October 4, 2022

Re: Public Comment Overview - File No. 2207-019 / 6950 SE Maker Street / Parcel
No. 9350900620

We are commenting on this proposed project because we believe the GFA calculation and the existing grades designated by the applicant do not comply with the Mercer Island City Code (MICC). We also have several concerns and questions for the City that pertain to the geotechnical and storm drainage report of which we request be answered. Additionally, due to the complexity of the proposed project, site considerations by the geotechnical consultant, and tight confines of Maker Street, we are requesting the City require a Construction Management Plan be filed. And lastly, based upon our understanding, the MICC tree code may have been violated, and we've provided information pertaining to that issue.

TOPOGRAPHIC & BOUNDARY SURVEY
PARCEL NO. 9350900620

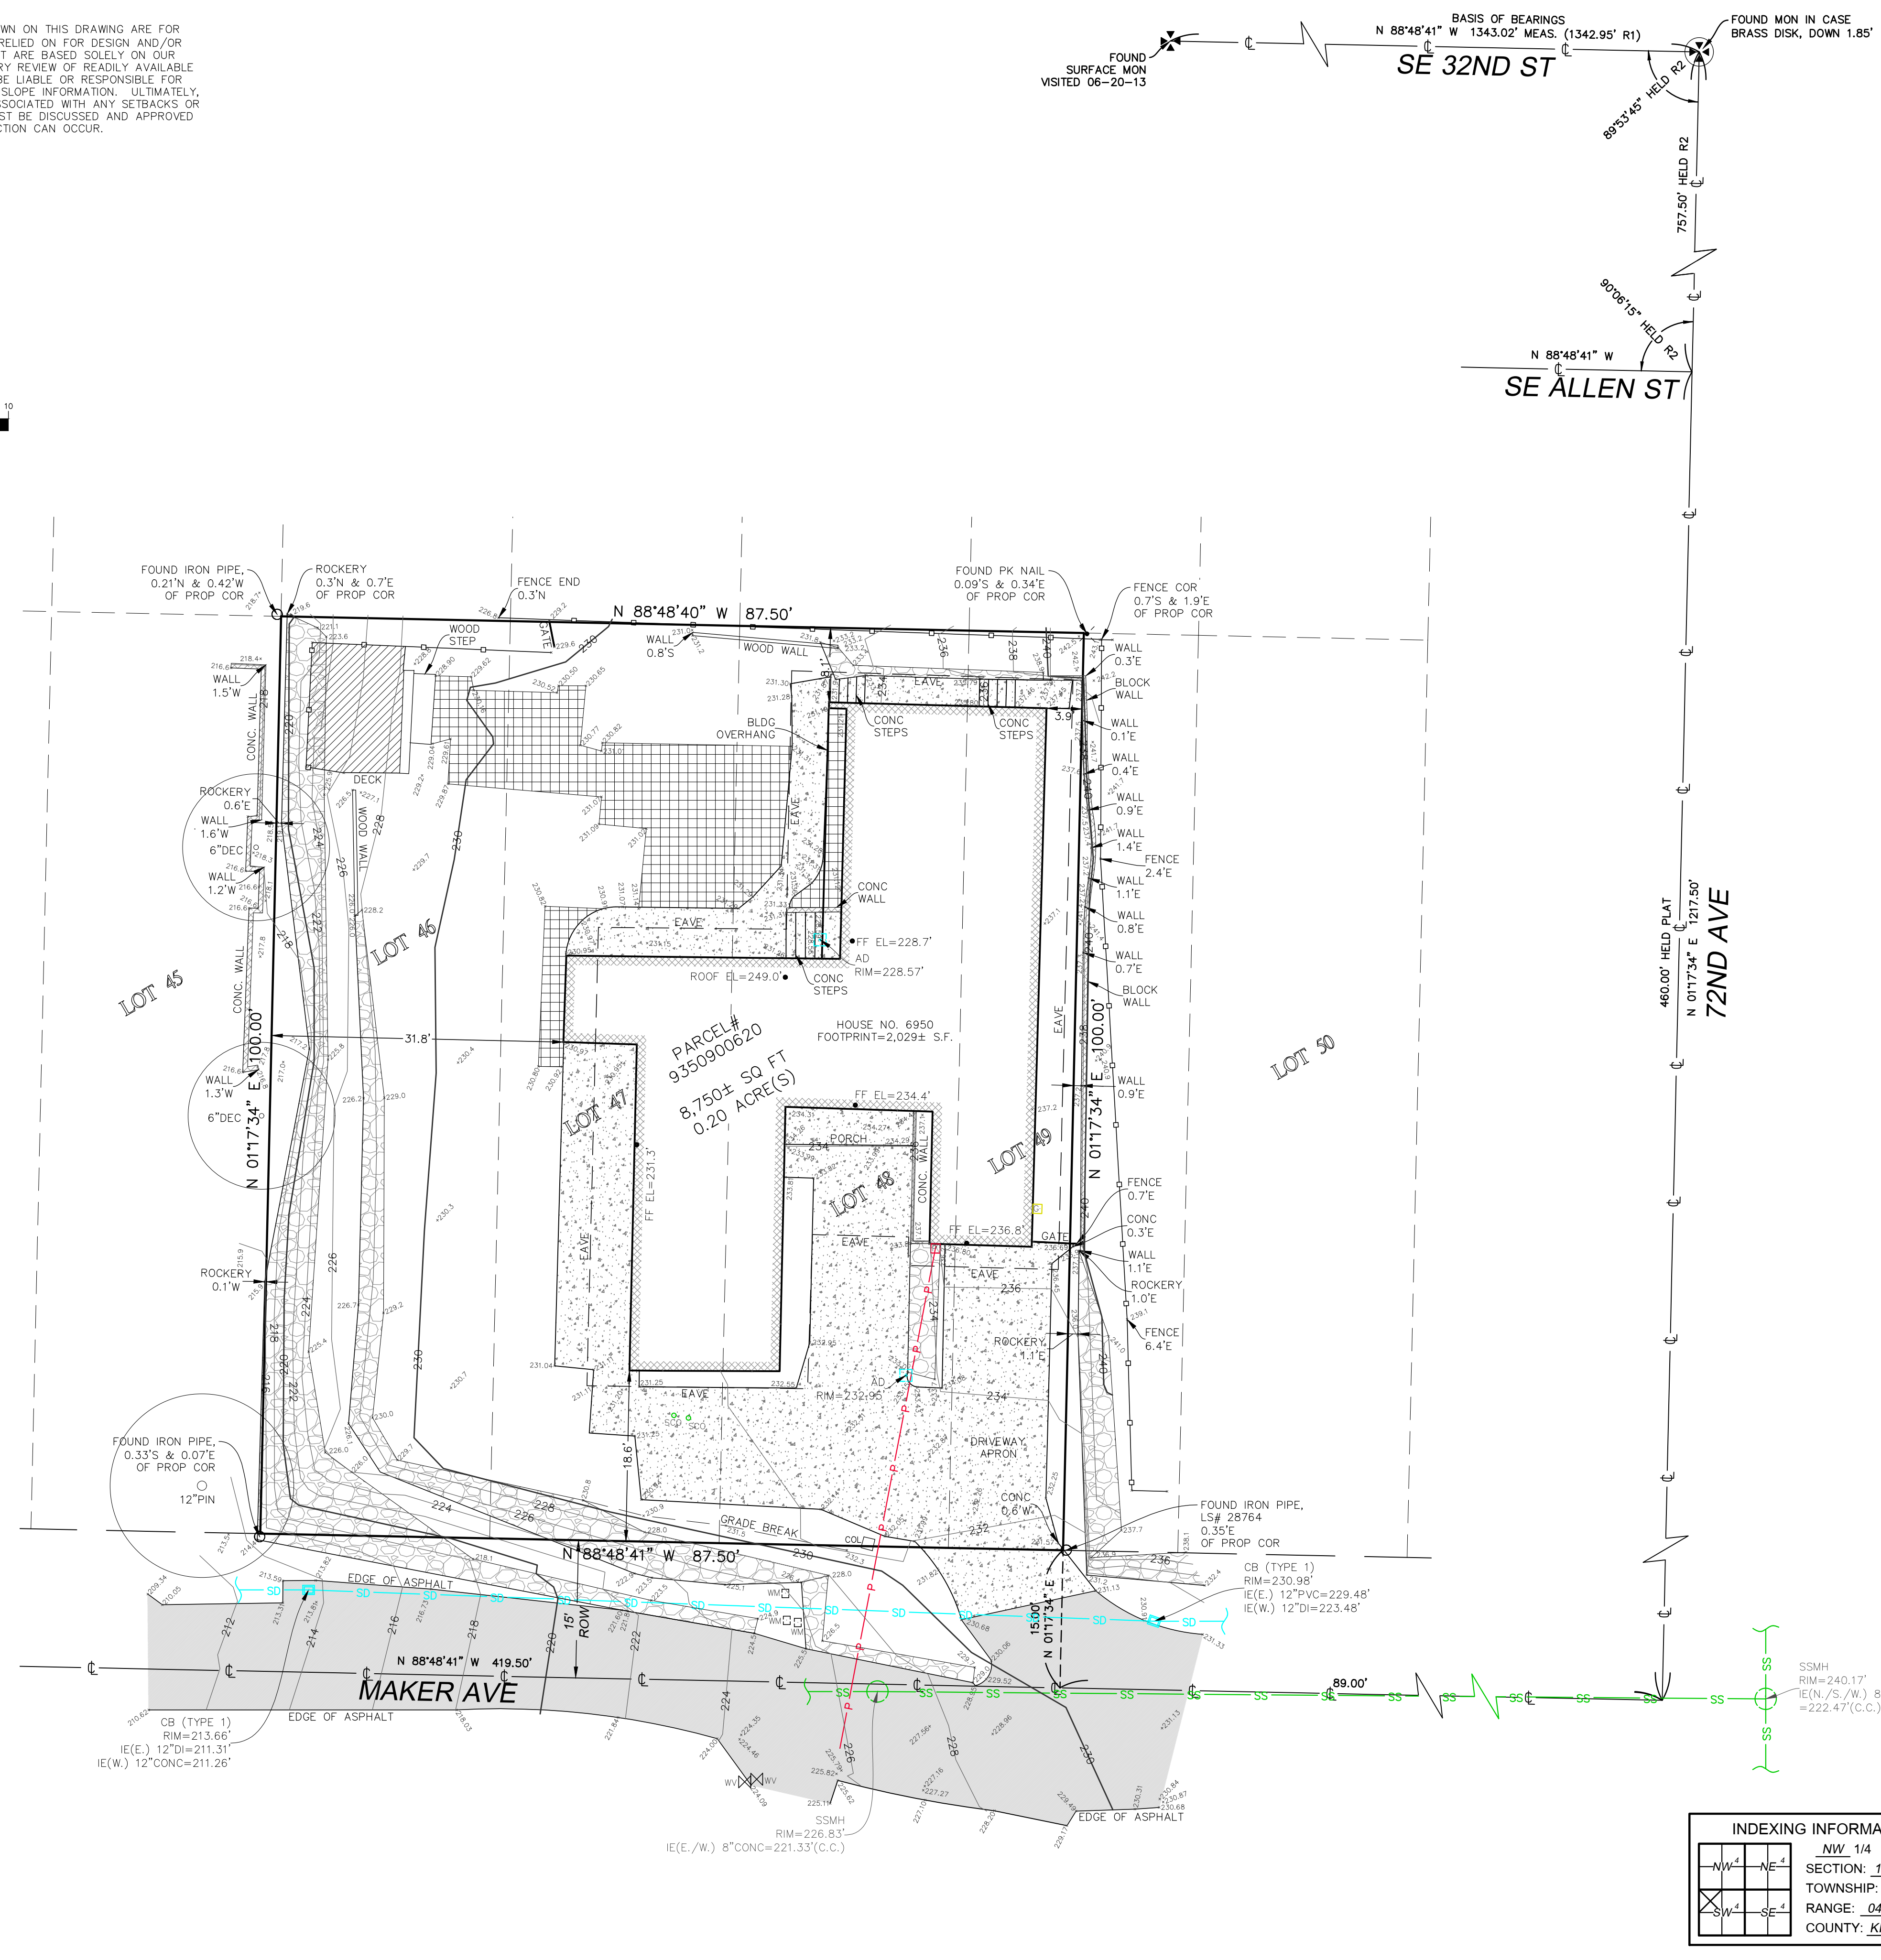
(Please note, we do not agree that most of the spot elevations and contours shown on Terrane sheet 1 of 1 meet the MICC definition of existing grade, however we did use them to illustrate our points above.)

A majority of the spot elevations and contours on the survey plan, Terrane sheet 1 of 1, which are designated by the applicant for design of the proposed project, do not meet the MICC definition of *existing grade* and more extensively, *alteration* and therefore, do not comply with the MICC.

Having researched and reviewed all of our data, including that of Dan Grove's, we believe there is enough concrete evidence to show that the designated existing elevations used for design and proposed construction do not fit the definition of *existing grade* and *altered* and thereby do not comply with the MICC. In addition, by virtue of the geotechnical and survey information we provided, we believe the existing grade, for example, on the west portion of the proposed structure lies many feet lower than the designated existing grades currently proposed. At a minimum, 224.0 - 225.0 seems highly plausible, but in all likelihood it could be much lower than that.

BASEMENT PLAN

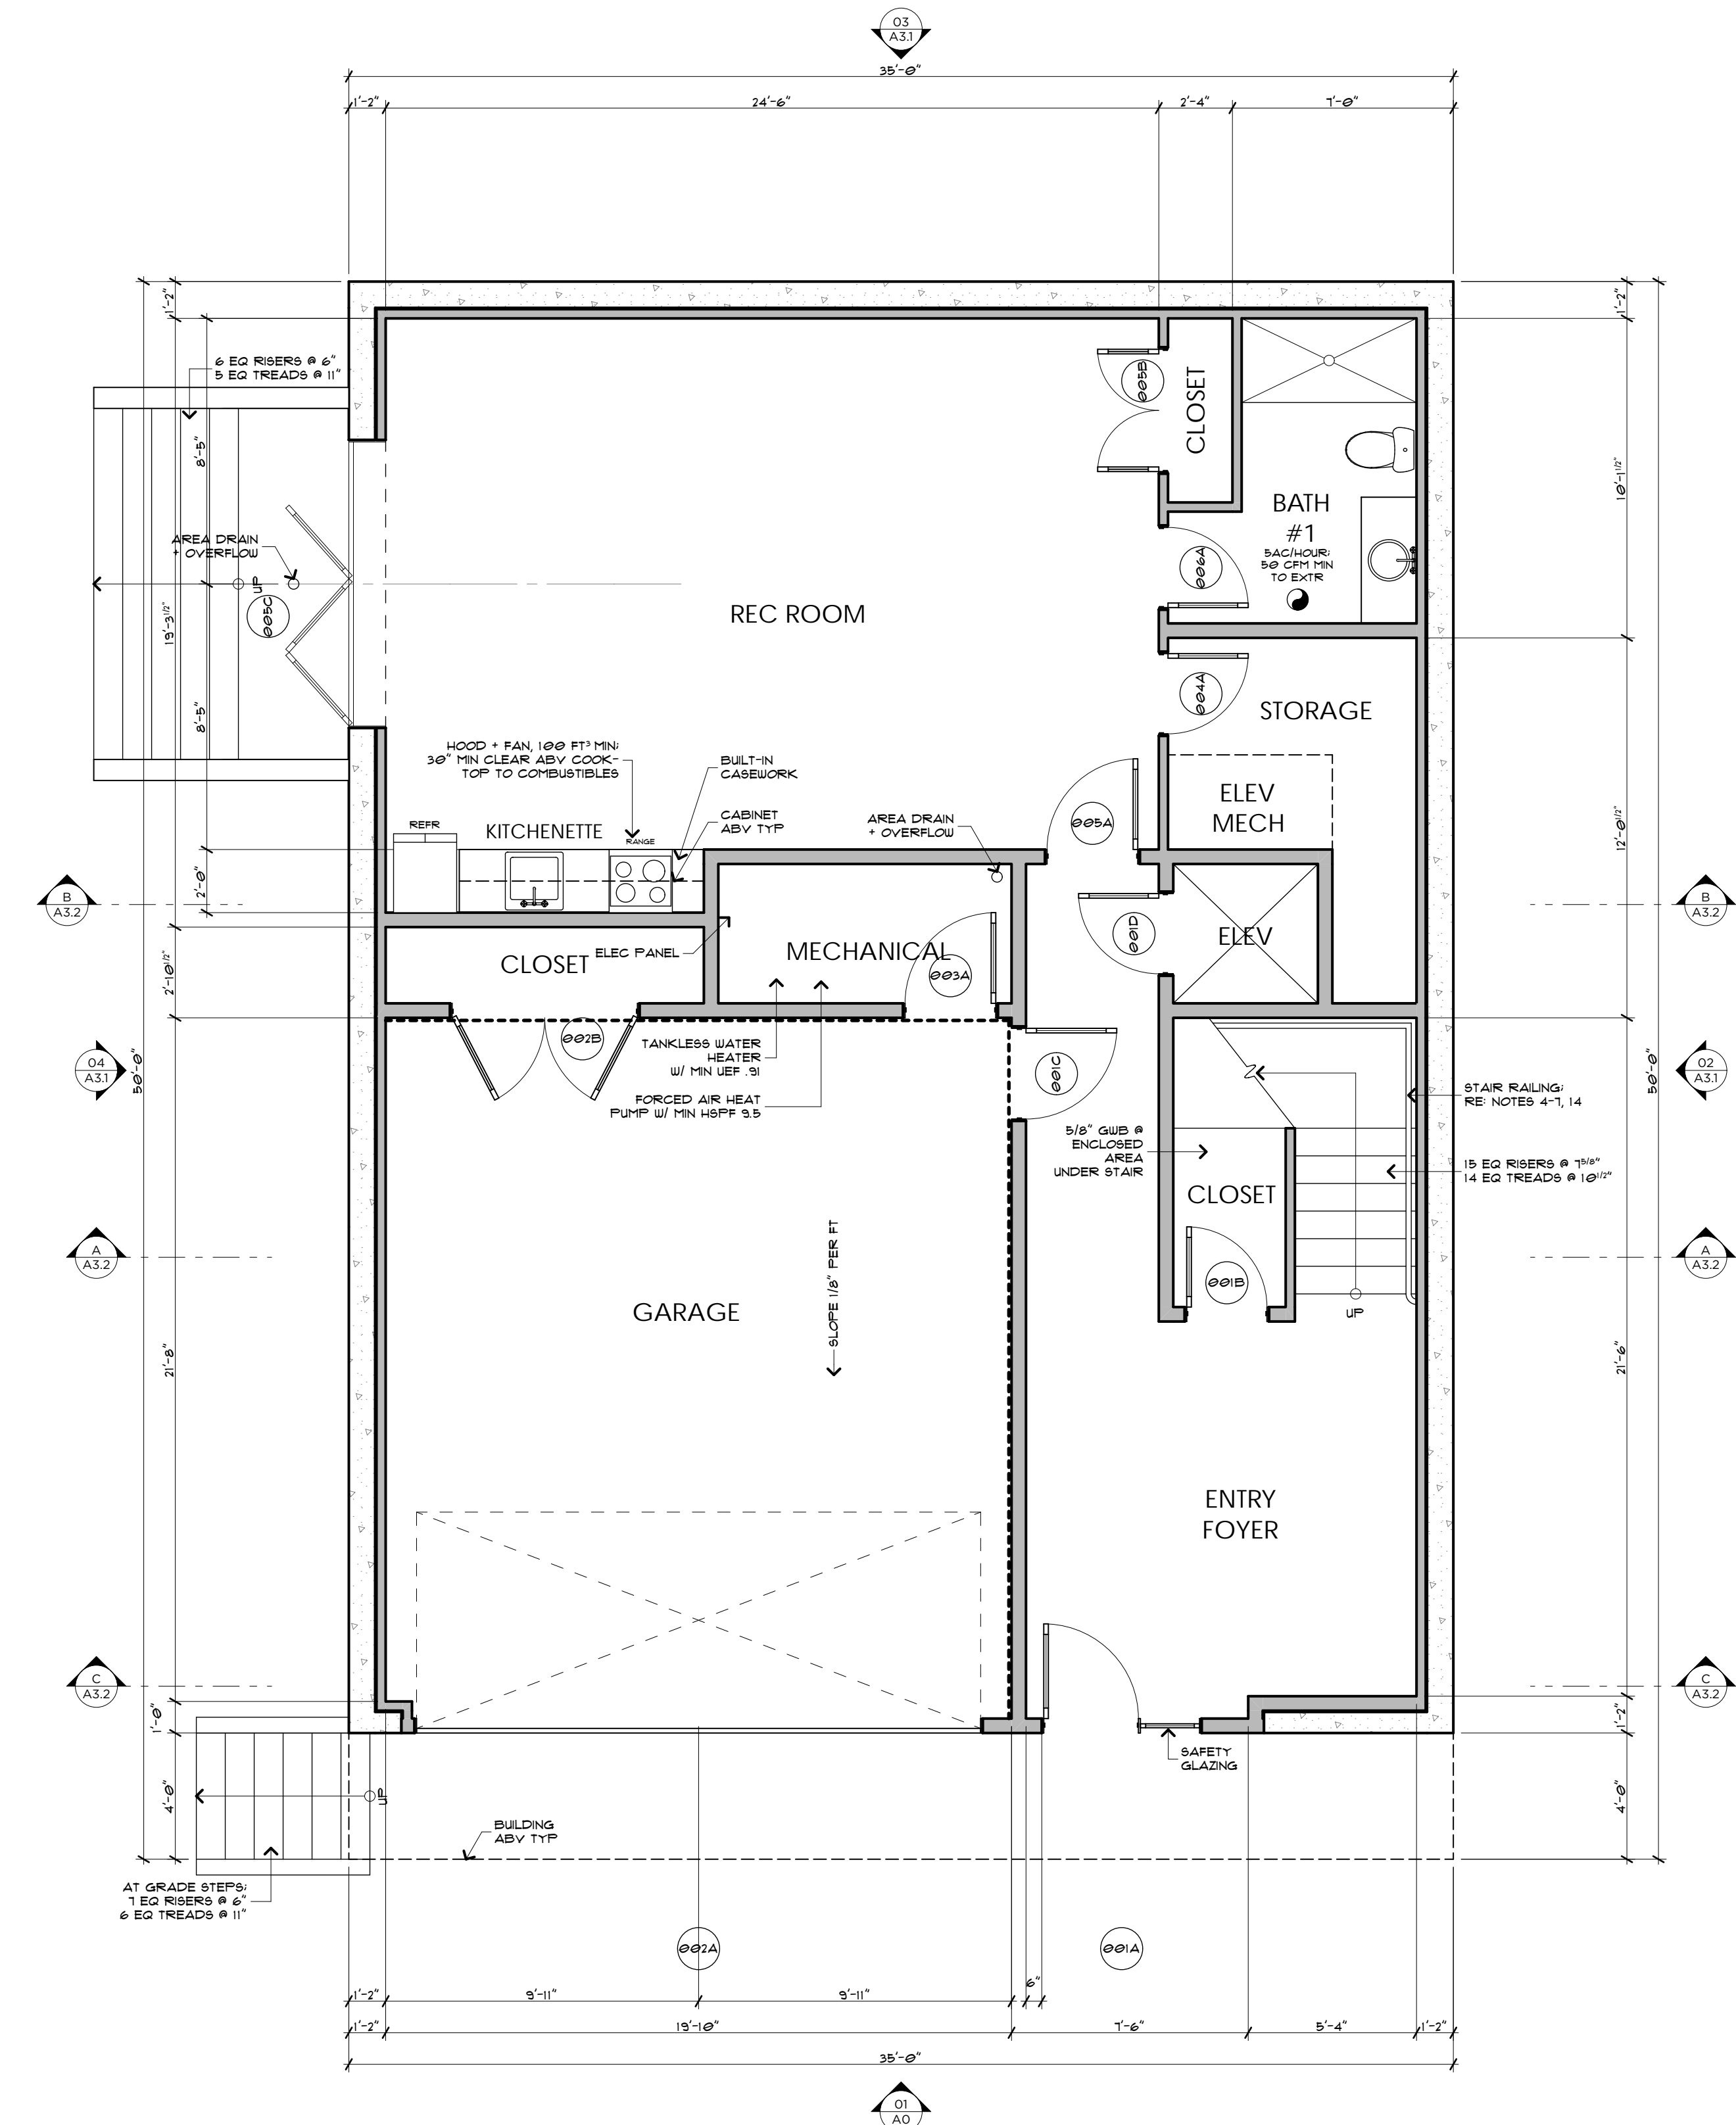
The GFA calculation for the basement/garage level of the home is incomplete and does not comply with the MICC. Furthermore, when the GFA is correctly and fully applied to all floors, it exceeds the MICC GFA coverage of 40% for R8.4 zoning, and therefore does not comply as well.

We have reviewed the proposed construction plans and noted that the project consists of a basement/garage and two wood-framed levels totaling approximately 5,073 sf. The maximum allowed GFA for this project is 40% or 3,500 sf (3,498 sf and 39.9% actual) as summarized on sheet A1.0. (There was not a basement floor plan drawn or GFA calculations included in the plans, only a summation of floor-by-floor totals was provided.)

The summary excluded 100% of the entire 1,575 sf basement/garage from the total GFA. We checked the applicant's MI Site Development Worksheet, and it also excludes the entire

basement/garage square footage from the GFA exclusion calculation netting out again at 3,498 sf. To better understand this, we researched the MICC and then ran our own GFA basement exclusion calculation based upon our understanding.

We determined that 51% or 803 sf of 1,575 sf basement/garage should be excluded from the GFA - not 100%. Our adjusted total is 3,498 + 772 basement inclusion = 4,270 sf which exceeds the 40% threshold.
